Please upload to A/131/15/RES & ENF/307/16 as 'part landscaping approval'  
Thank you

**From:** David Innes  
**Sent:** 23 May 2017 13:53  
**To:** Lisa Coney  
**Subject:** FW: STORE18832 17-18 Mill Lane, Rustington

We spoke earlier today regarding the Manor Retail Park development which was known as Mill lane when it when it went through the planning process. The email below refers.

scheme: Mill Lane Site
Rustington
client: Store Property
drawing: Landscape Proposals
date: July '15
scale: 1:200@A1
drawing no: STORE18832 17J
drawn: DKM checked: AE

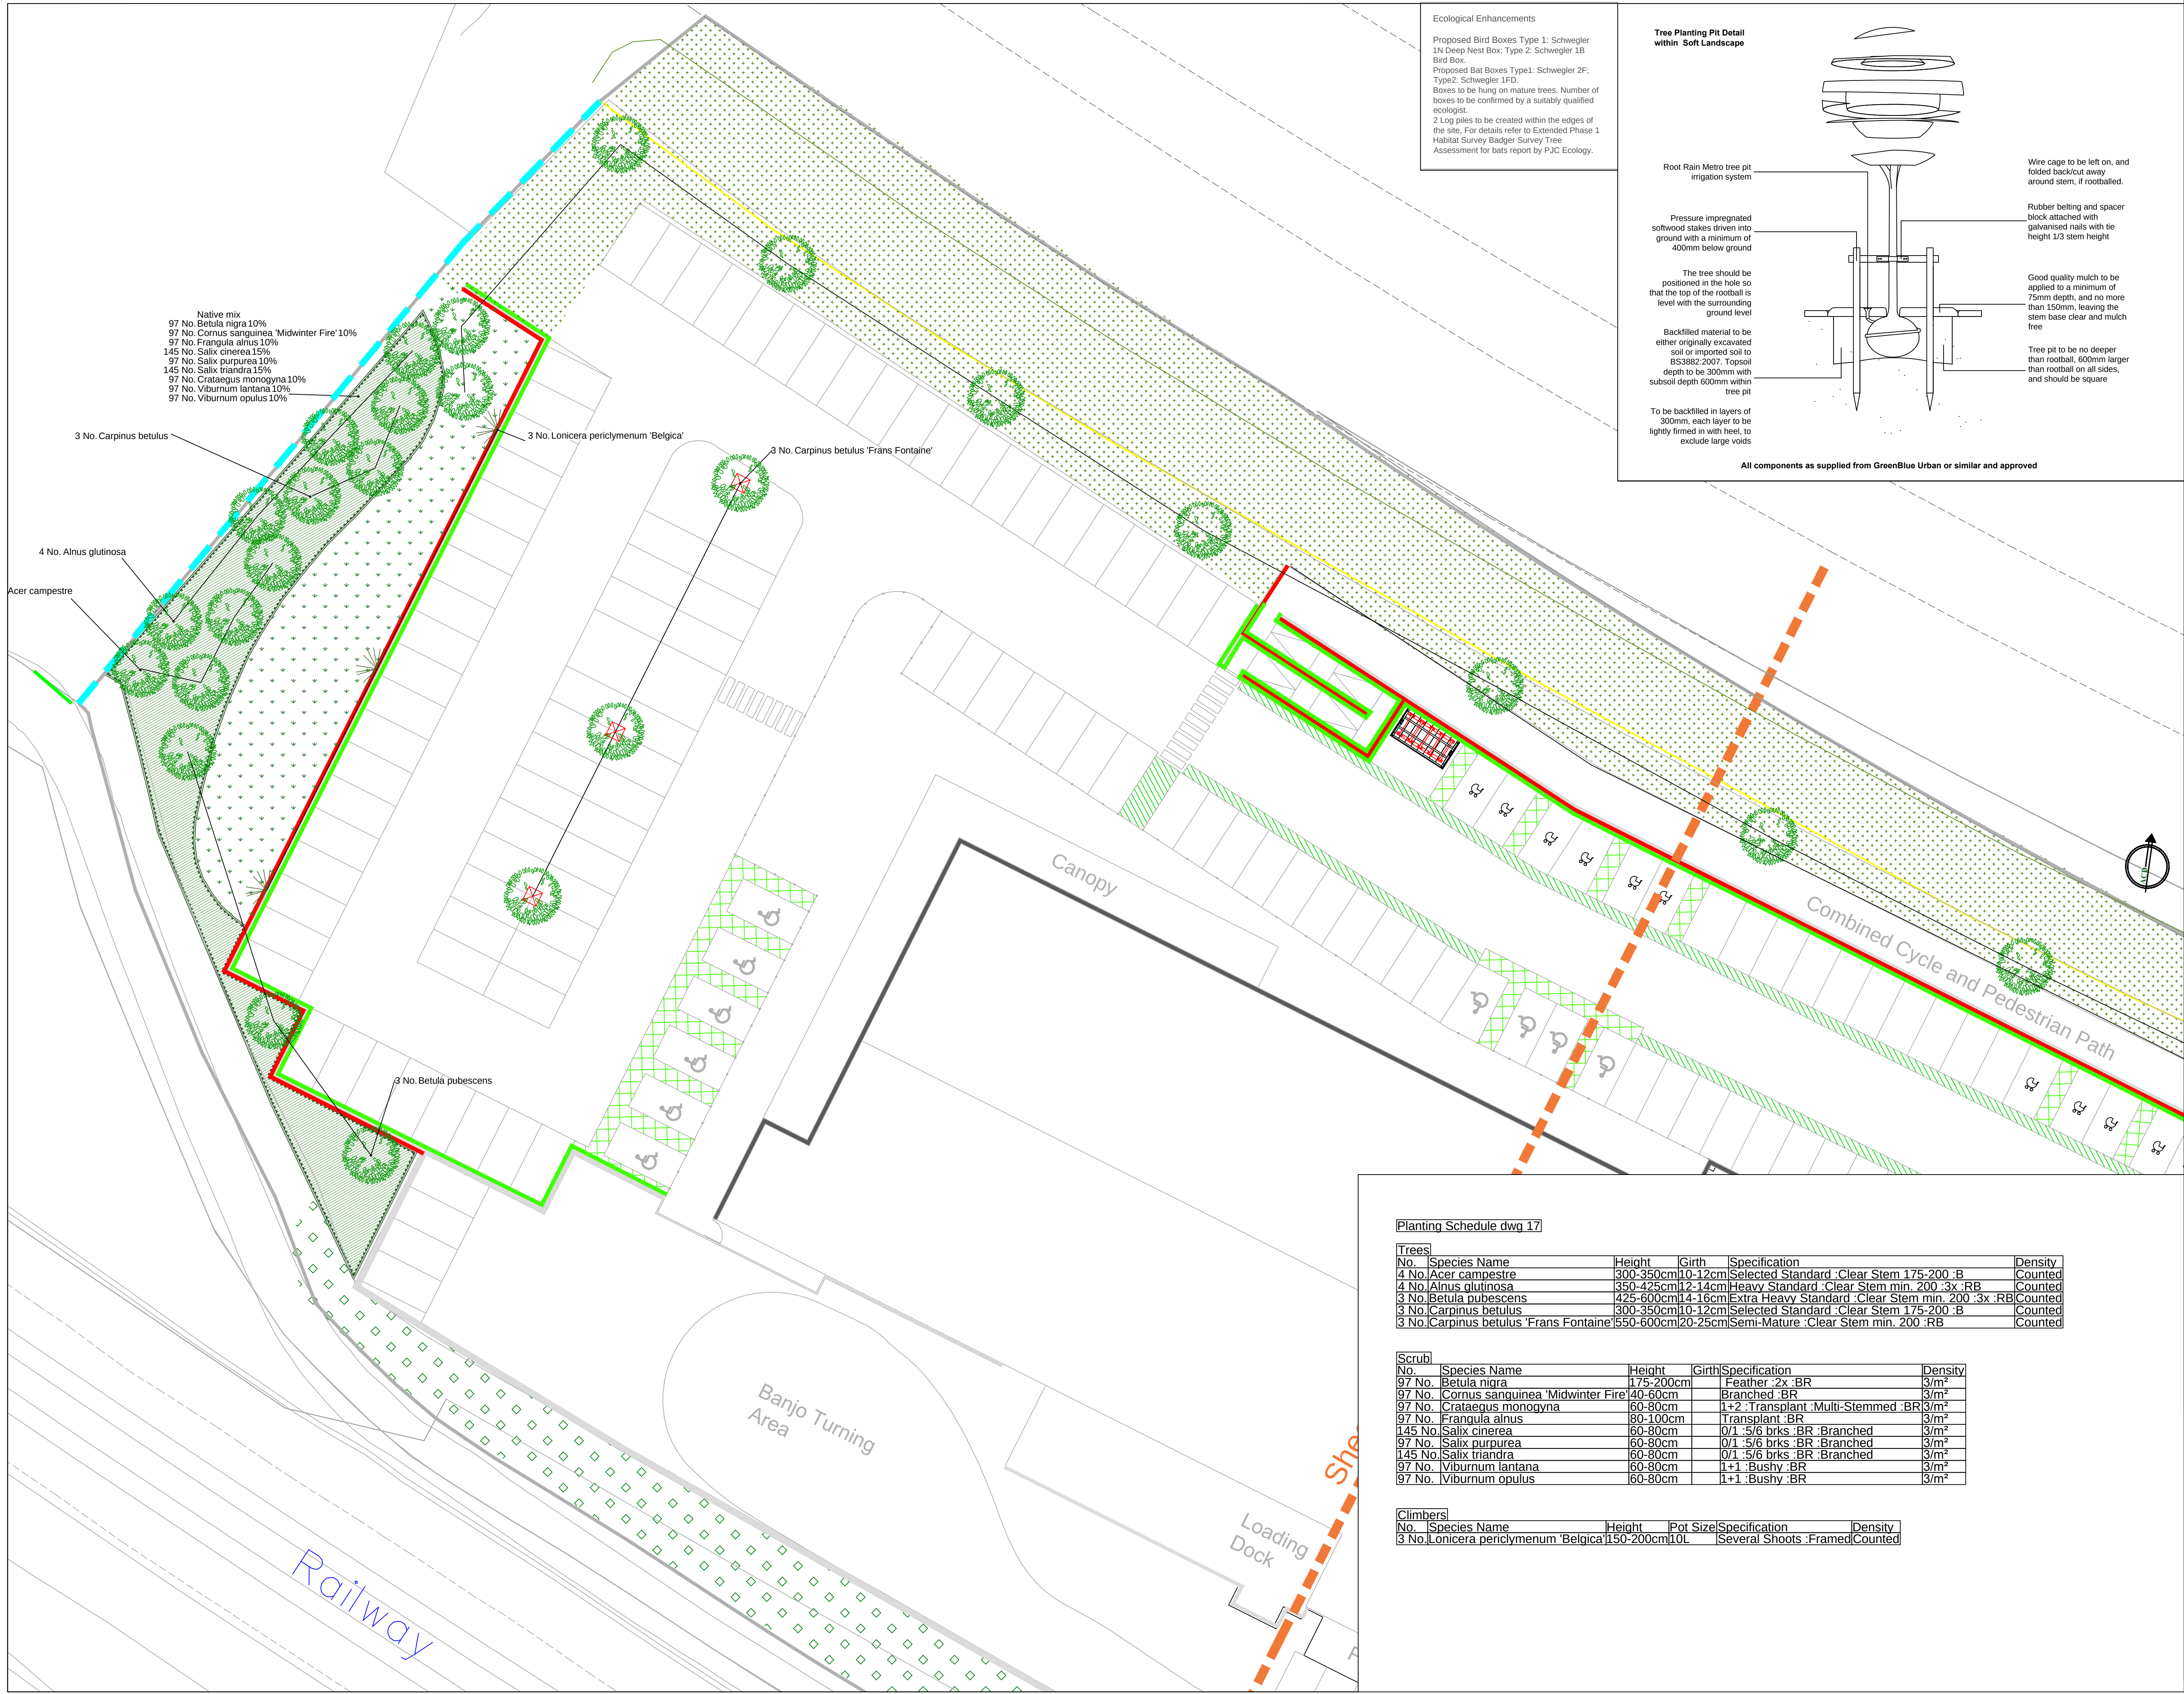
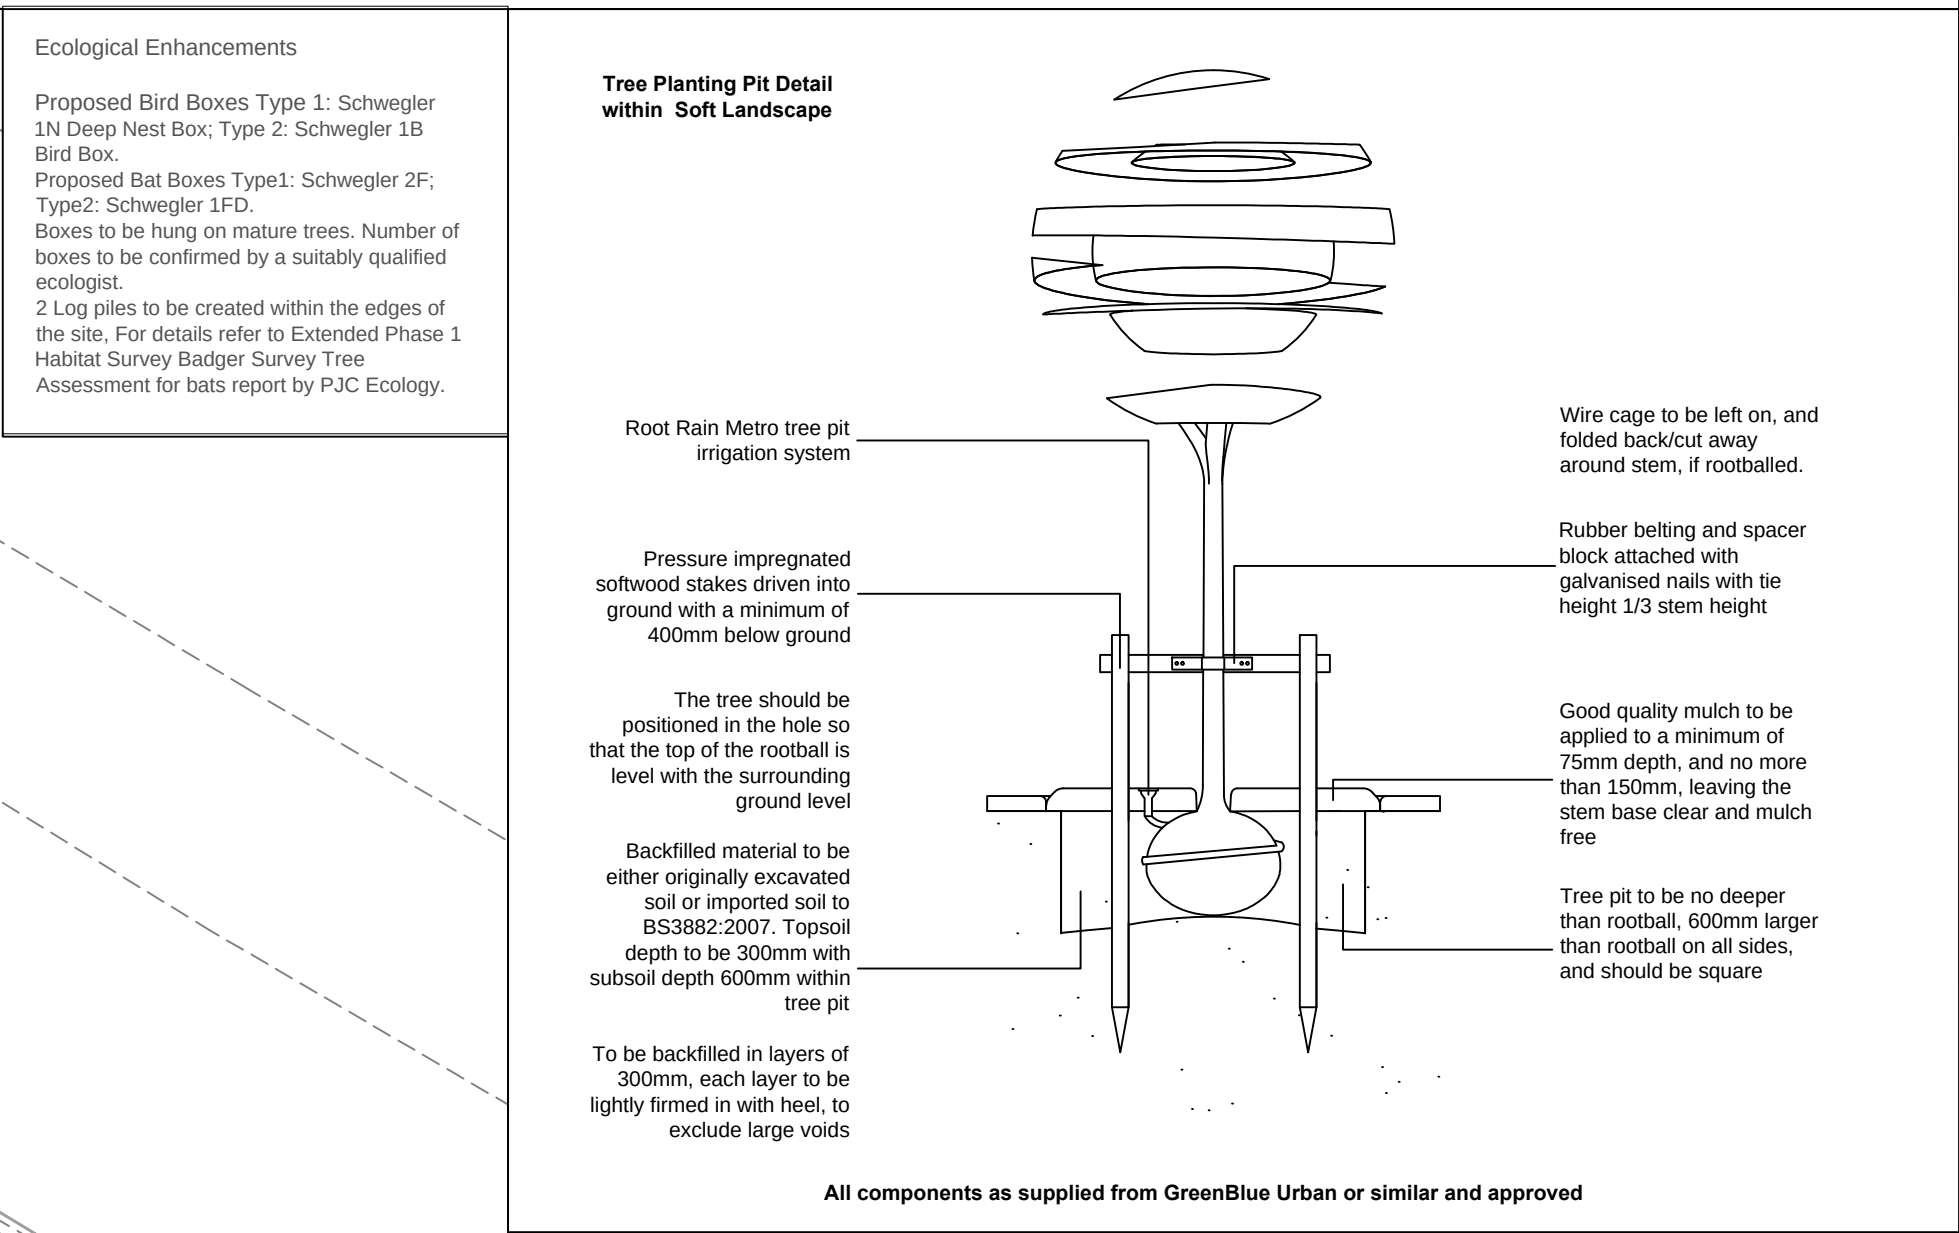
You may recall we took a bit of time getting improvements to the planting scheme, are the three replacement trees acceptable in this location? Please see the email from Ross below

I can confirm that the only change from the consented drawing relates to 3 three trees in the middle of car park shown on drawing 17Q. The tree was changed on advice that the originally chosen tree species would have great difficulty surviving in this location due to the way the site drainage works.

The original tree was a *Carpinus betulus* 'Frans Fontaine'. We have planted three *Sorbus aucup.* 'Sheerwater Seedling

Quick response from Landscape Architect. As long as these alternatives have gone in at same spec as the planting scheme these will be acceptable.

I can confirm that 3no Sorbus aucuparia. 'Sheerwater Seedling' are a suitable alternative and assuming planted at the same size spec then I am happy that these are suitable alternatives.
